Ribble Valley Borough Council  
Development Control

Application no: 3/2020/0754  
Address: 33 Littlemoor Road Clitheroe  
Proposal: Conversion of car port to Garage

Proposed Front Elevation

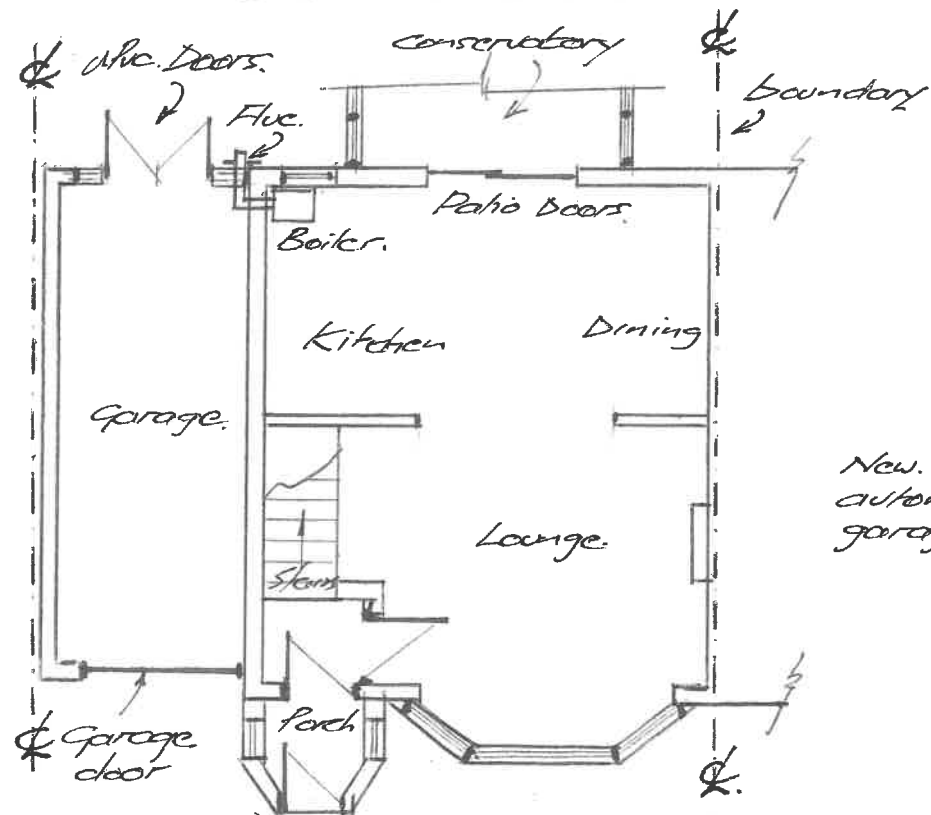
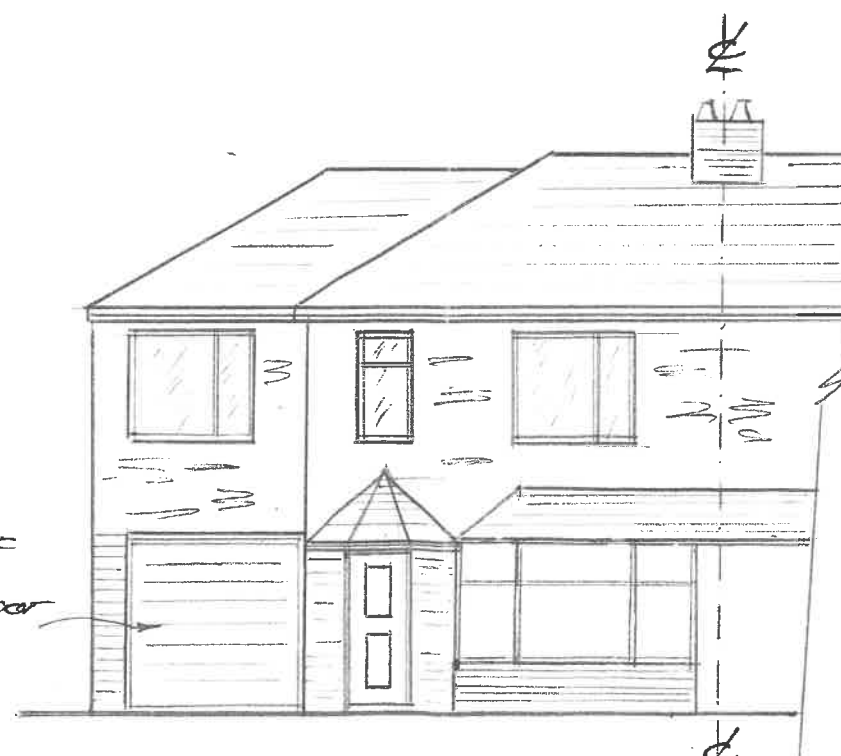
The proposal is for the conversion of a car port to a garage. Having visited the site, enclosure of the car port to the front elevation has already been carried out in a style that would not support a retained use as a garage. Nevertheless the property benefits from 2 parking spaces to the front garden and this being the case I would raise no objection to the proposal on highway grounds but the vehicle access crossing would need to be widened accordingly and I would therefore suggest that the following note be attached to any permission that may be granted.
